CITY OF ALBUQUERQUE

January 25, 2017

Re: Arroyo Vista Apartments
4201 Bryn Mawr Dr. NE
Traffic Circulation Layout
Architect's Stamp 11-04-16 (G16-D0153)

1. ASPHALT PAVEMENT DRIVEWAY AND PARKING SPACE STRIPING.
2. SWIMMING POOL - SEE POOL DRAWINGS.
3. CONCRETE SIDEWALK. 4,000 PSI AIR ENTRAINED CONCRETE MIN. - SEE DETAIL 2 / AS2.1

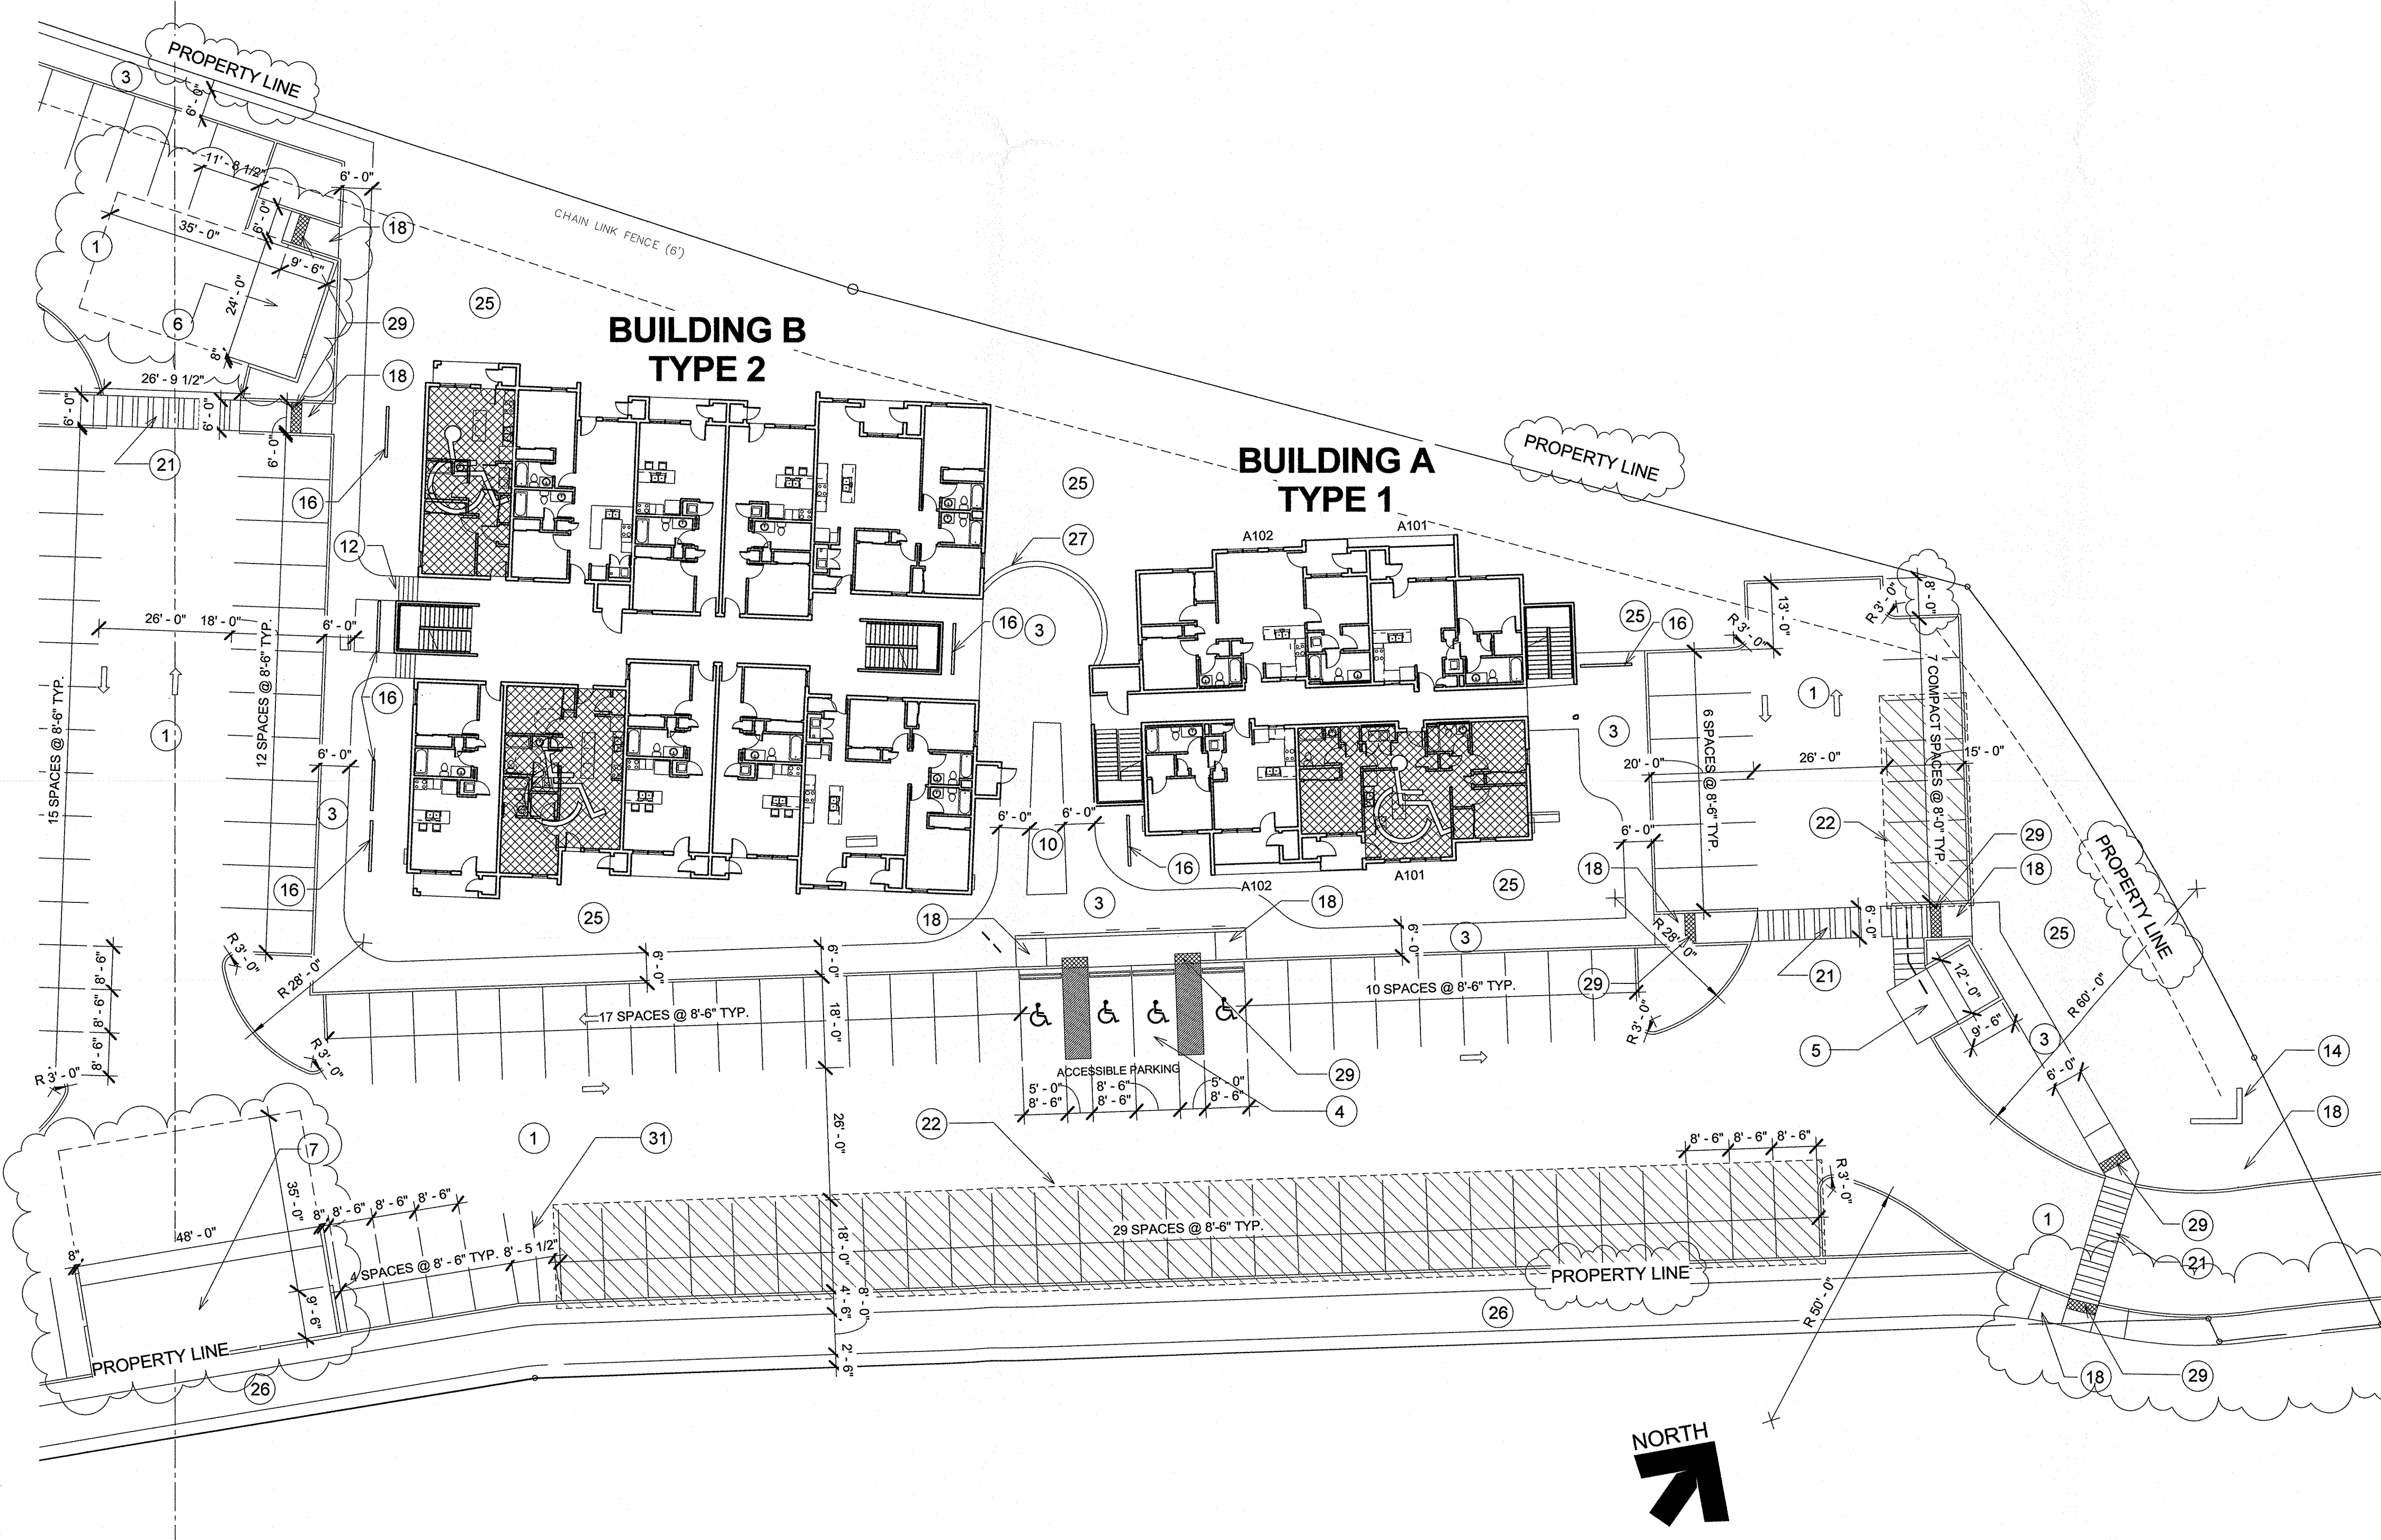
2. Identify all existing access easements and rights of way width dimensions. Please provide an exhibit for all accesses to site.
3. Identify the right of way width, medians, curb cuts, and street widths on Pan American NE and Bryn Mawr Dr. NE. Correct the road name Pan American Fwy NE to Pan American NE.

4. Clarify existing property lines and proposed property lines. Also include any easements existing or proposed.
5. Use match lines on plans to show continuation on second page.

6. Label the compact parking spaces by placing the words "**COMPACT**" on the pavement of each space.
7. The ADA access aisles shall have the words "**NO PARKING**" in capital letters, each of which shall be at least one foot high and at least two inches wide, placed at the rear of the parking space so as to be close to where an adjacent vehicle's rear tire would be placed. (66-1-4.1.B NMSA 1978)

8. The ADA parking space has a clearly visible, blue, International Symbol of Accessibility painted on the pavement at rear of the space (66-1-4.1.E NMSA 1978) or MUTCD recommends a white symbol on a blue background.

9. Please dimension all pedestrian path ways and crosswalks. Some dimensions are not shown. Add ADA note referring to cross and running slopes for pedestrian paths. The site looks to have large grade changes.

10. Detectable warning surfaces, truncated domes should be used at curb ramps crossing vehicular traffic. Please provide details referenced in TCL keyed notes.

11. Clarify connection to Maintenance building between the handicap parking.

12. Dimension the drive aisle width off of Bryn Mawr.
13. List radii for all curves shown; for passenger vehicles, the minimum end island radius for passenger vehicles is 15 ft. Radius for delivery trucks, fire trucks, etc. is 25 ft. or larger. The secondary entrance could use a larger radius than 12 feet.

14. A 5 ft. keyway is required for dead-end parking aisles. Please add dimensions on the TCL.
15. Per the zoning code, a 6 ft. wide ADA accessible pedestrian pathway is required from the public sidewalk to the building entrances. Please clearly show this pathway and provide details.

16. Per DPM, a 6 ft. wide ADA accessible pedestrian pathway is required from the HC parking stall access aisles to the building entrances. Please clearly show this pathway and provide details.
